**From:** [Virginia Waller](#)  
**To:** [Robin Proebsting](#); [Scott Greenberg](#)  
**Cc:** [Debbie Bertlin](#); [Cindy Goodwin](#); [Julie Underwood](#)  
**Subject:** Re: Thrift Shop and Parking Expansion  
**Date:** Friday, January 27, 2017 3:47:42 PM

**RESPONSE:** It sounds like the document you're referring to is the one labeled "Site Paving Plan", on which reinforced turf is shown alongside the existing access path on the west side (i.e. away from the parking lot) near SE 34th, then east of the existing path, closer to the trees as it bends heading northward. It appears that this plan is showing how adequate fire access (e.g. lanes wide enough for a fire vehicle to drive, turns of an angle a fire vehicle could make, fire lanes close enough to every point in the building etc.) could conceivably be provided.

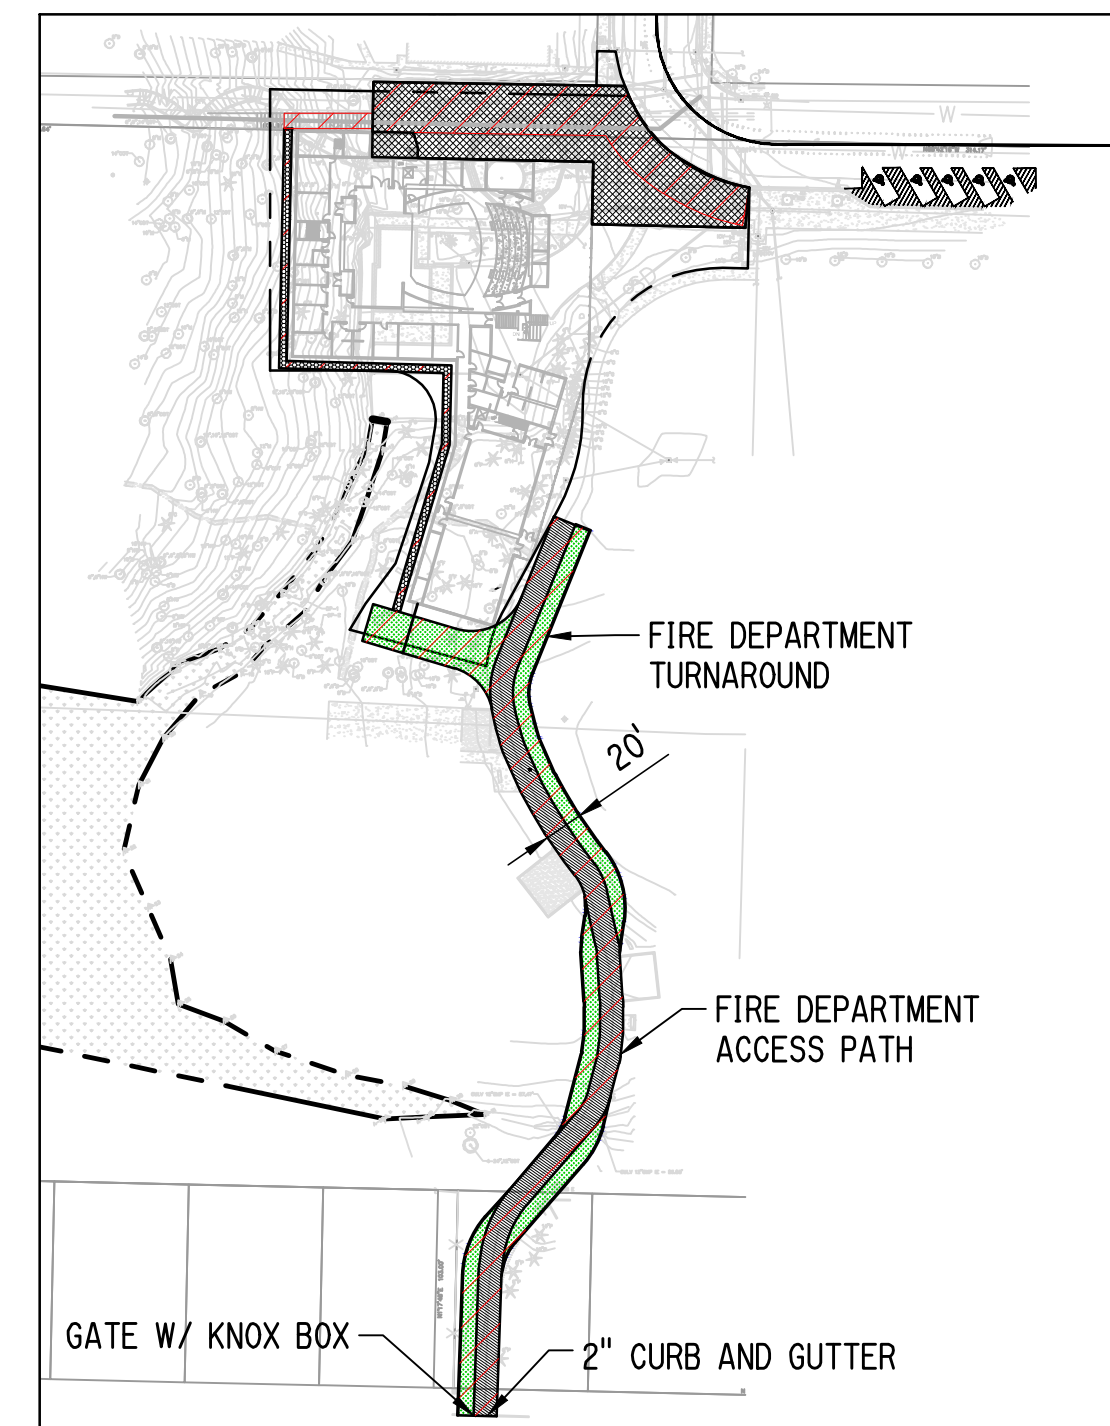
Also, I understand that the Fire Code requires that if the fire lane is longer than 150 feet, which I think it will be if it runs from 34th Street past the skate park, fire trucks must have a large turnaround area at the end, or it needs to exit onto 32nd. I'm getting inconsistent information on the turnaround circle that will be required at the end, but am told it will need to have a diameter of 70' to 100' to accommodate the fire trucks. Is this accurate? And if so, why is this not shown on the diagram?

> I saw an updated MICA plan last week, which now includes a 20' wide fire road starting on 34th (in a residential neighborhood) and running alongside the edge of the Thrift Shop parking lot where there is now a walking path. To accommodate the proposed width, I wonder if some parking spaces might be impacted -- the pine trees will almost certainly need to be removed. And the newly-installed exercise equipment in the park will likely be impacted. The 2-lane road goes into the park, stopping just past the skate park.

> I am concerned this road will become a dropoff for MICA vendors and visitors. And this road will prevent expansion of the parking lot (something I'm not particularly sad about, in truth, but thought the Thrift Shop should know).

> At this point, there is a ton of traffic that comes off 78th and into the Mercedale neighborhood. It is not fair to allow this to increase substantially because of MICA, and a fire lane dropoff will almost certainly attract users. Can the fire road be blocked off with a gate that only the fire department can open?

This is not the type of plan that would be used for street construction--it does not show enough detail for that purpose. It is possible that there could be impact to trees, however at this of review, staff are looking at conceptual plan. These do not have enough detail to provide a certain answer. The City does have codes pertaining to tree retention, and at the construction plan review stage, the applicant will need to show they are meeting tree retention codes.

**RESPONSE:** The site plan shows a gate at the south end of the fire access path (the SE 34th St side) and a "Knox Box", which is a system that allows a gate to be locked, but still allow for emergency access quickly. This indicates that the intent is to keep the gate locked but available for Fire Department access only.

**RESPONSE:** No storage of any type can be on any area that is a fire lane.
